**KIRKLEES COUNCIL
TOWN AND COUNTRY PLANNING ACT 1990
HIGHWAYS DEVELOPMENT MANAGEMENT**

PLANNING REF 2018/62/91661/E0/GW
CATEGORY Small Major

PROPOSAL OUTLINE PERMISSION FOR RESIDENTIAL DEVELOPMENT AND FACILITATING ENGINEERING OPERATIONS AND FULL PLANNING PERMISSION FOR ACCESS AND SPINE ROAD

LOCATION LAND AT WALKLEY TERRACE AND BRUNSWICK STREET, HECKMONDWIKE

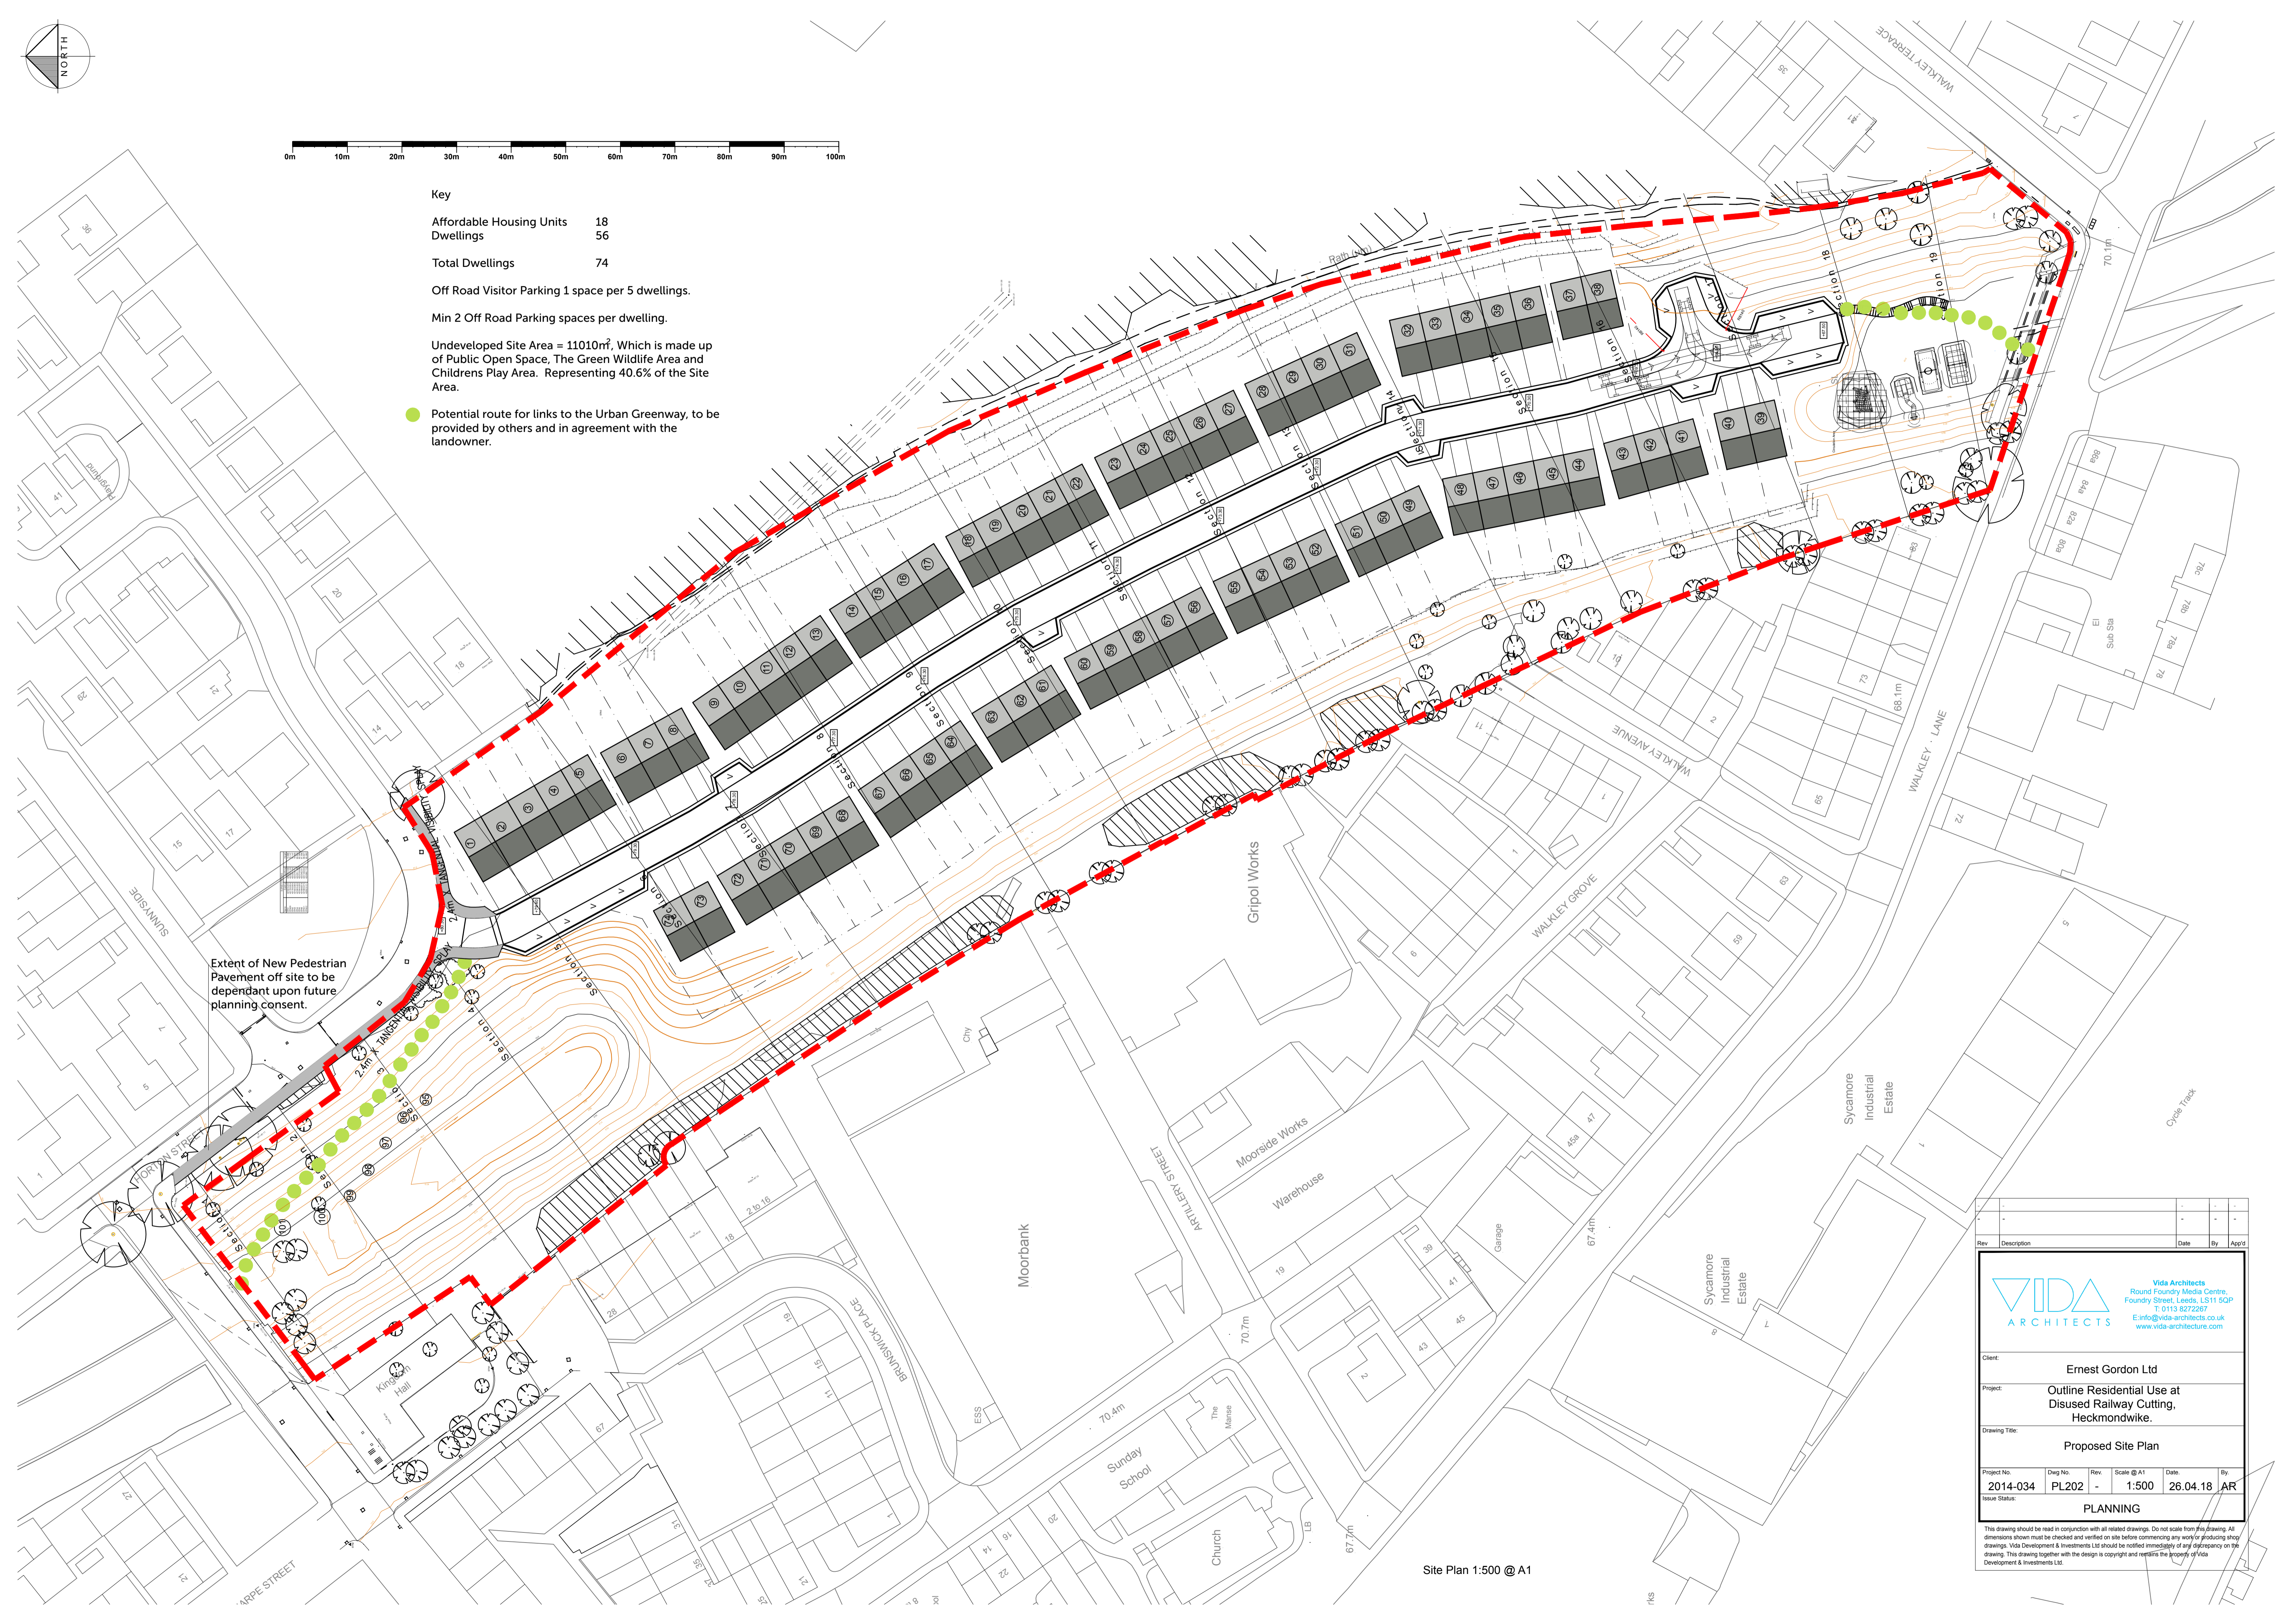
The proposed visitor parking spaces are not well spaced along the length of the proposed road. They are also insufficient in size and the splays are insufficient. Visitor parking bays should be 6.0m at the rear with 30 degree splays.

It is proposed to provide 2 off-street parking spaces per dwelling which is only acceptable if the proposed dwellings have 3 or less bedrooms. Larger dwellings will require 3 off-street parking spaces.

No house types are provided and the parking strategy needs to be clarified.

Bin presentation points should be shown to be provided to each dwelling. These should be sited to allow bins to be presented without obstructing the highway or the access to driveways.

There is no pedestrian link to Wesley Terrace
